Objection (3) and request for plan of proposed front wall and gate posts and gates - Brus Lodge, 28 Kingsway – 26-7-2017

Head of Planning Application,
Arun District Council
Maltravers Road
Littlehampton
BN17 5LF

OBJECTION (3) TO AW/155/17/PL and FURTHER REQUEST FOR DETAILED CONSTRUCTION PLANS OF PROPOSED WALL, GATEPOST'S, AND DRIVE AREA

Existing + Proposed Street Elevation

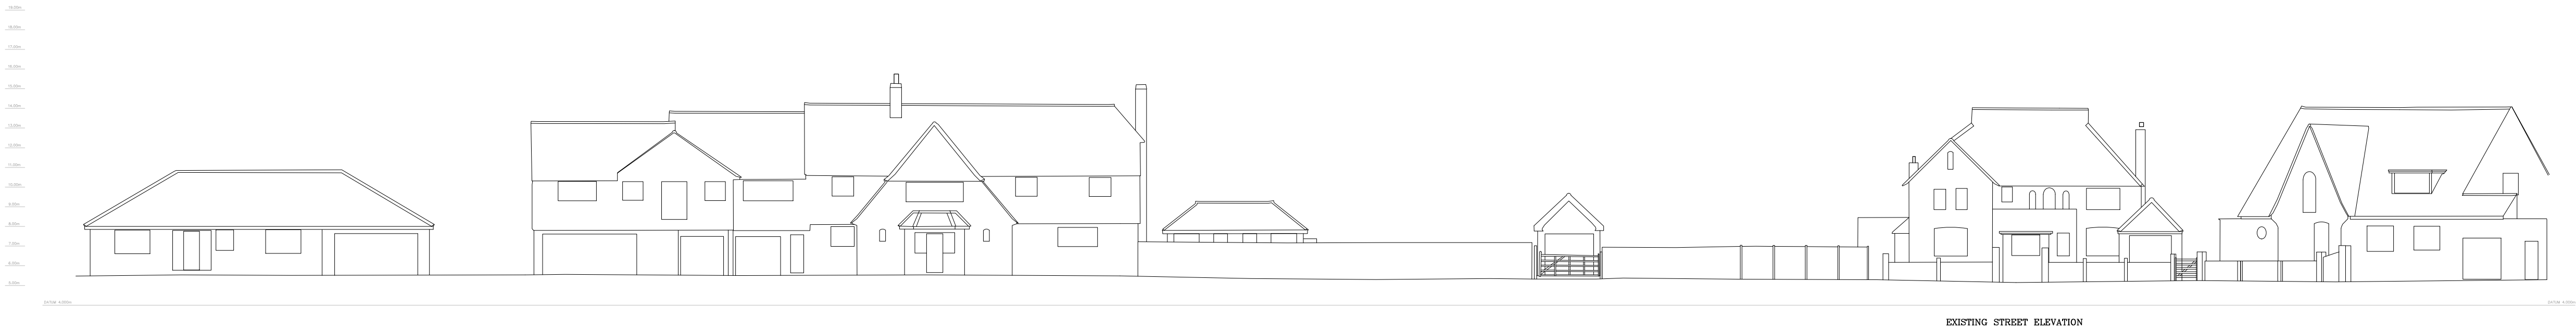
We say again that we need to know the dimensions, design and materials, including sections, showing the footings and foundations, including dimensions, of the walls, brick gate piers to be able to assess them as part of the application.

No such plan has been published on the website or made available to us and it has to be emphasised, for your complete understanding and avoidance of all doubt, that this information is fundamental, also, in order to assess whether or not this aspect of the proposed development will have any adverse effect on trees and shrubs.
